Application no: **3/2021/0392**

Address: **20 Shays Drive Clitheroe BB7 1LL**

Proposal: **Proposed first floor extension over existing garage.**

The Local Highway Authority have viewed the plans and highway related documents and have the following comments to make:

Plans, Elevations & Section As Proposed

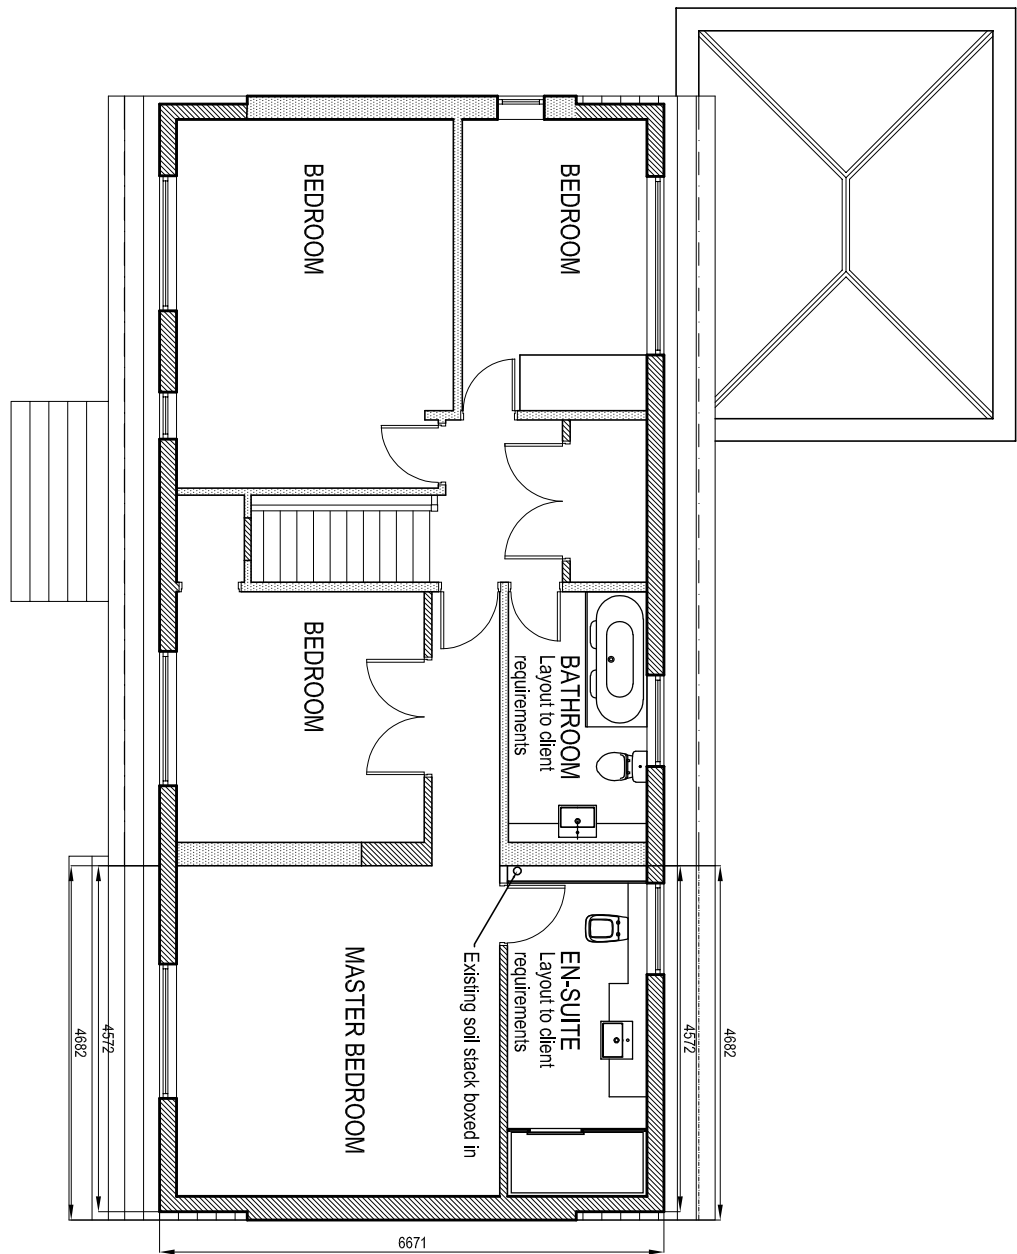
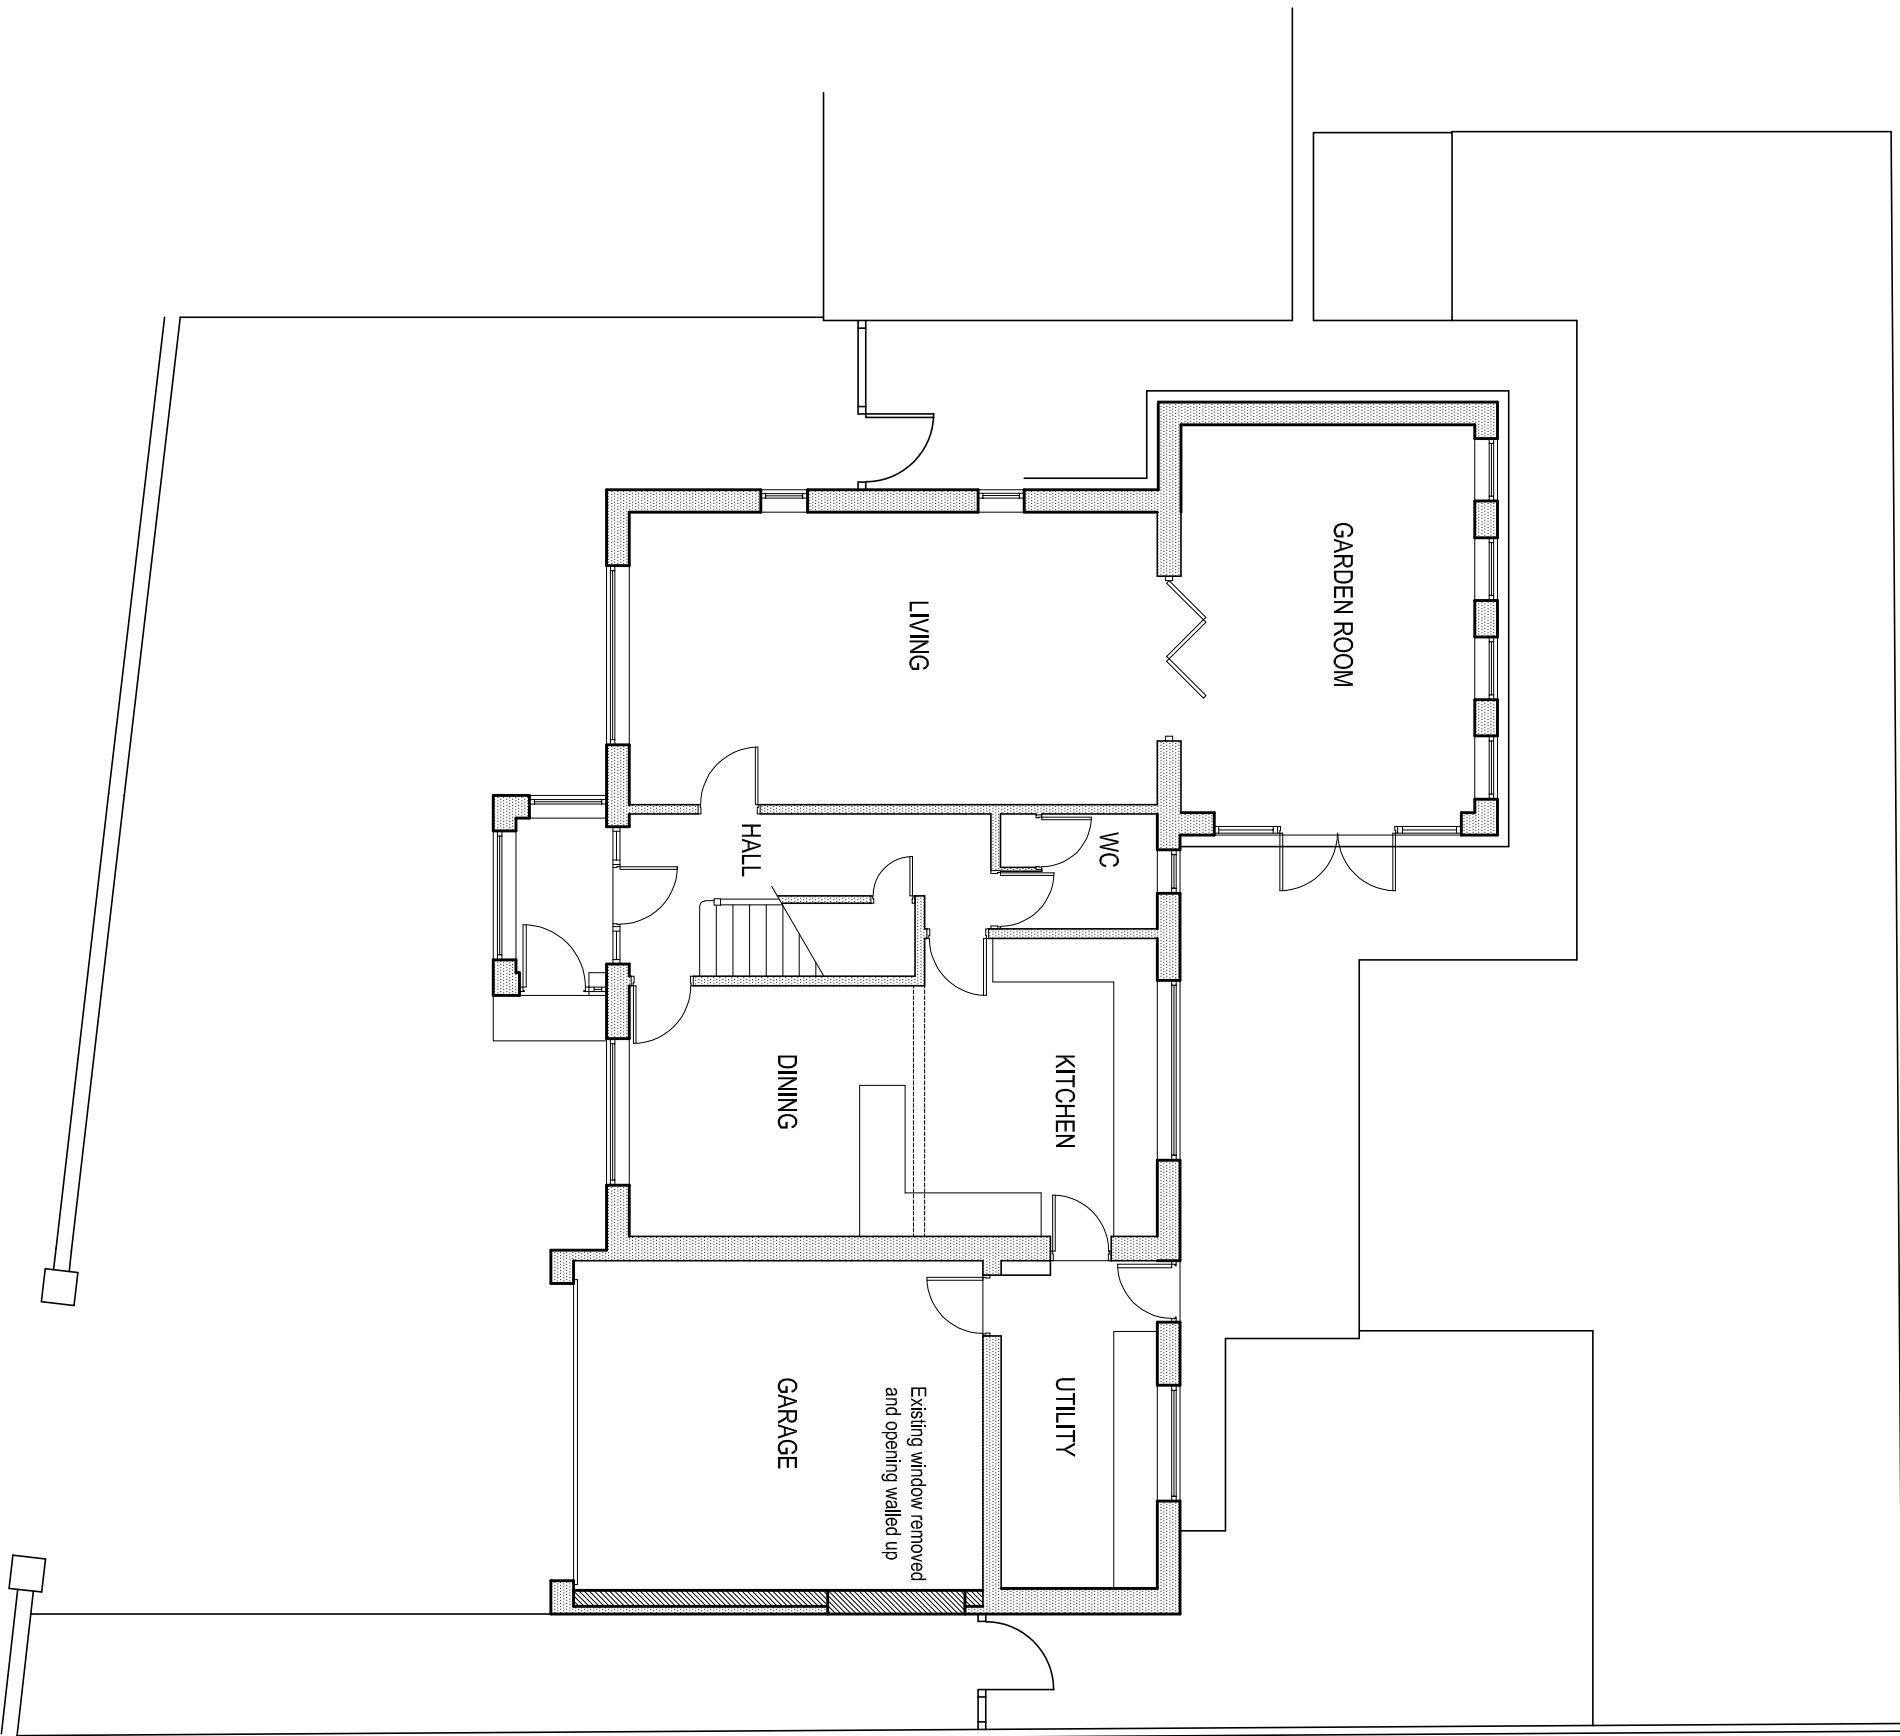
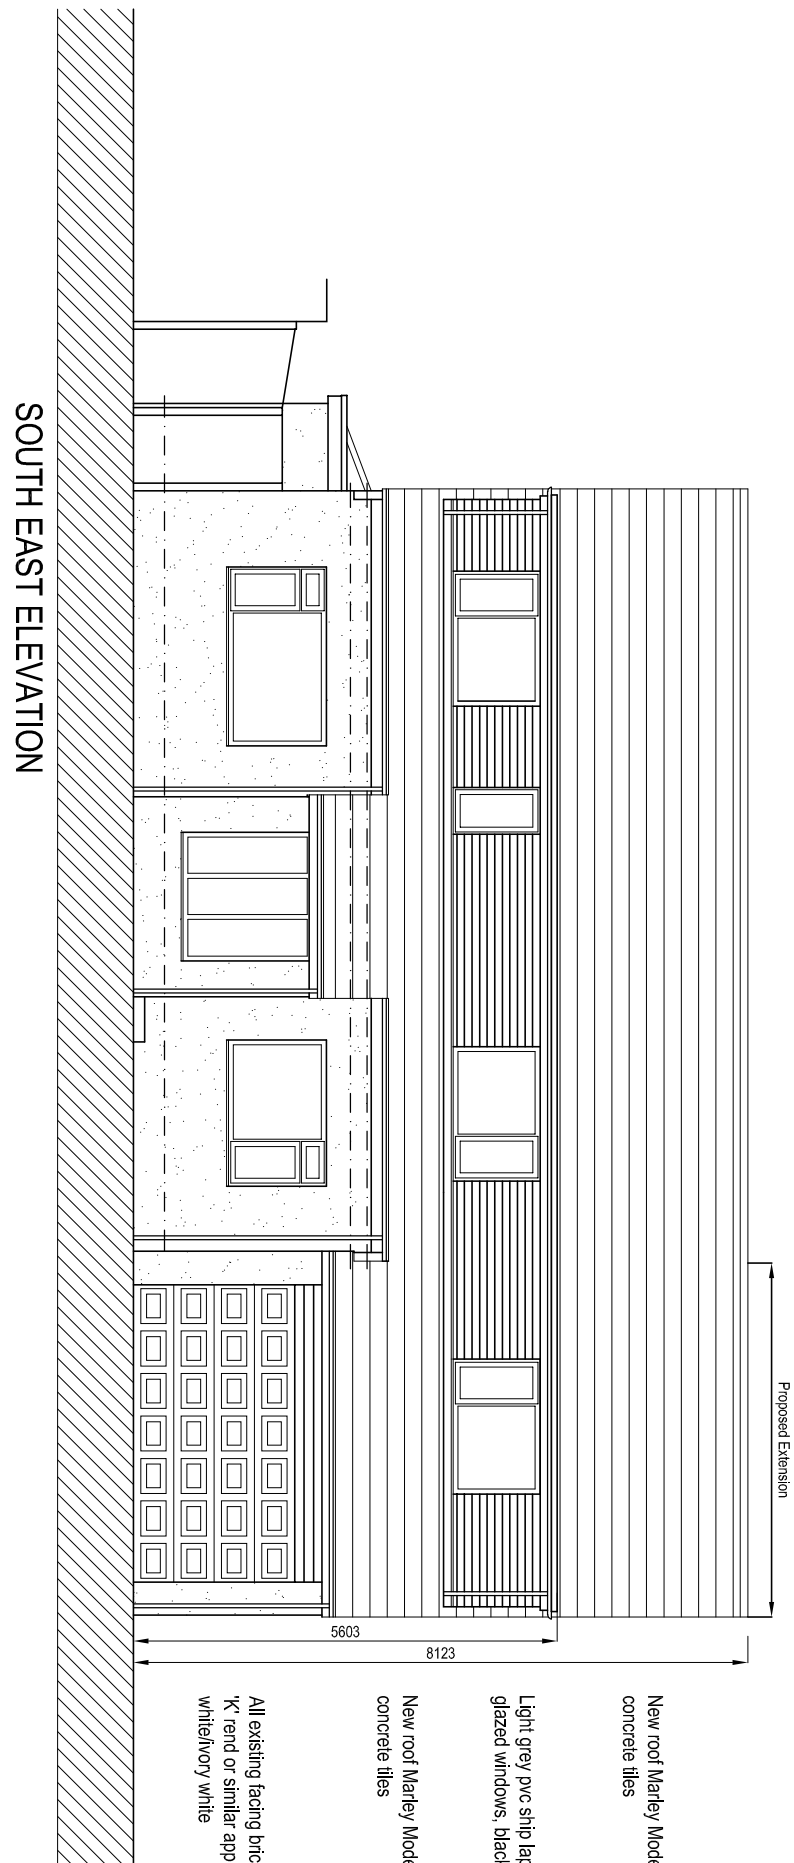
The LHA have also reviewed IP drawing number 3A titled "Plans, Elevation and Section as Proposed" and understands the proposal will increase the number of bedrooms in the house from 3 to 4.

For a 4-bed dwelling to meet the standards contained in the Joint Lancashire Structure Plan, the dwelling is required to provide 3 car parking spaces. However, the dwelling is only able to provide 2 car parking spaces, one space in the garage and one space on the driveway. Therefore, there is a shortfall in one space.

Notwithstanding this the LHA will accept the shortfall in one space at the dwelling, with the LHA aware of the recent planning history at the site, with the LPA permitting a similar scheme on two occasions. Furthermore, there appears to be adequate space for on-street parking and whilst this is not ideal the LHA would not advise refusal of an application based on a shortfall of one parking space when compared to the existing situation.
